M3 Junction 9 Improvement Scheme – TR010055

Reference: M3J9-EIA064

For Deadline 5 (D5), the South Downs National Park Authority (SDNPA) would like to make the following submissions.

Appendix A

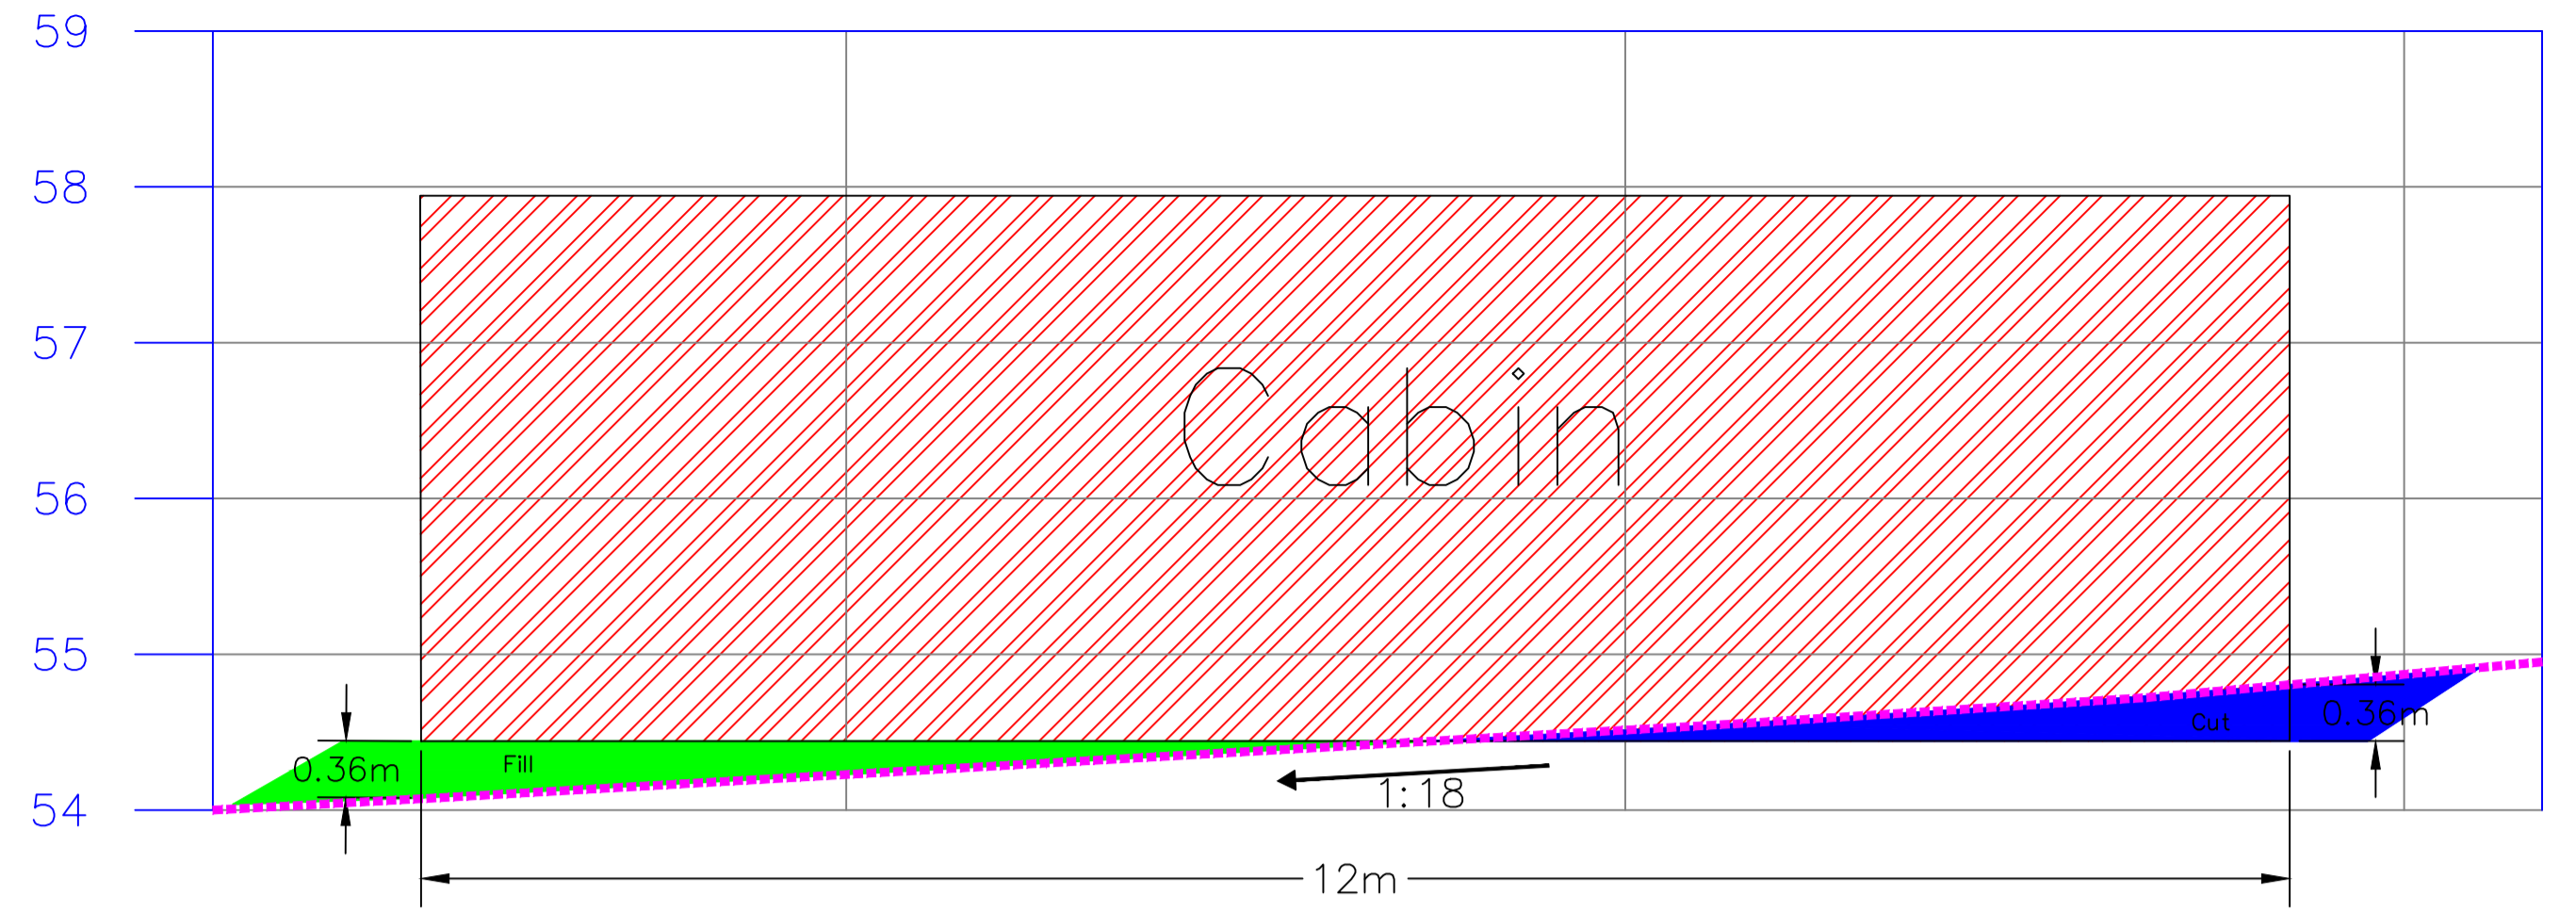
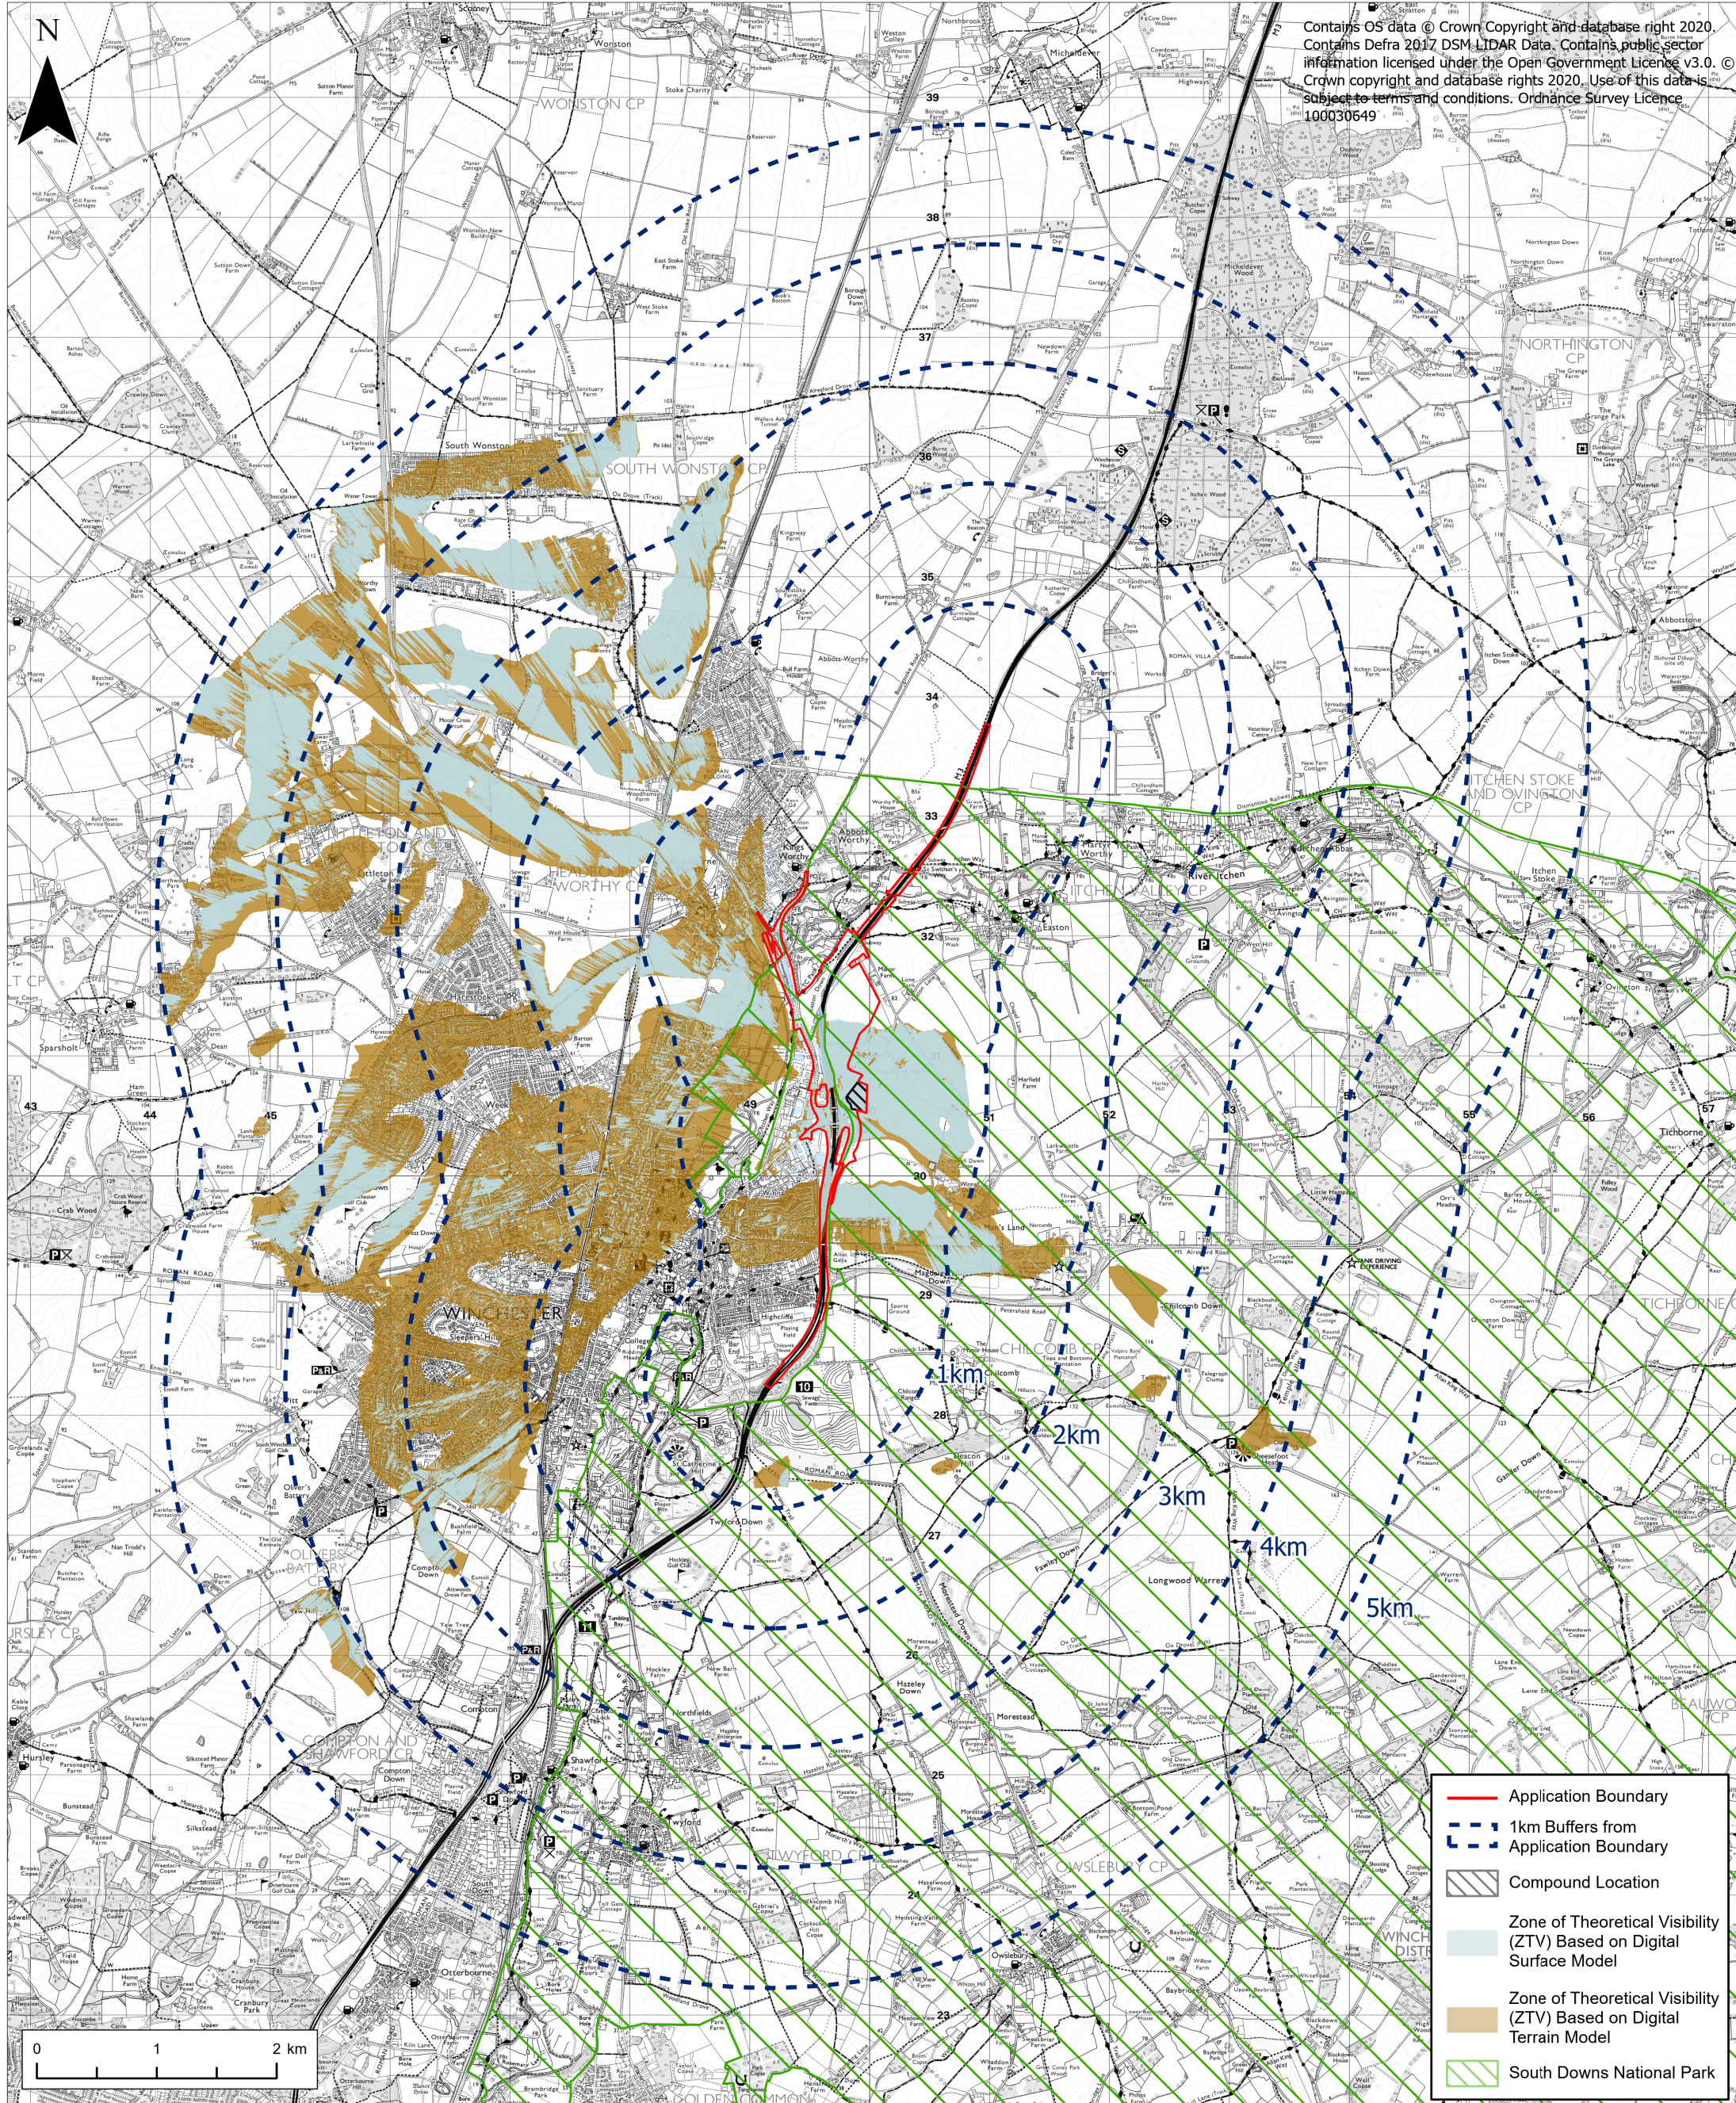
Question Reference	Examining Authority Question	SDNPA Response
Q12.2.7	<p>The Applicant's written summary of oral submissions for ISHI [REP4-034] includes Appendix D - Indicative construction layout. (i) Please comment on the indicative construction layout, the anticipated visual impact, and the degree of cut and fill that is shown to enable siting of the cabins (0.36m). (ii) The septic tank is shown on the layout plan. Please explain how it would be ensured that this would not have any adverse implications for any nearby private water supply and boreholes.</p>	<p>Please see response to Q12.2.6.</p> <p>Whilst the degree of cut and fill required does not appear excessive it is a simplified section and a reminder that there will be a constant need to reprofile land within the compound because of the existing rolling topography for features such as access roads, car parking etc. Whilst it is possible to reprofile this at the end of the construction period it is generally impossible to restore to the natural ground profile.</p>
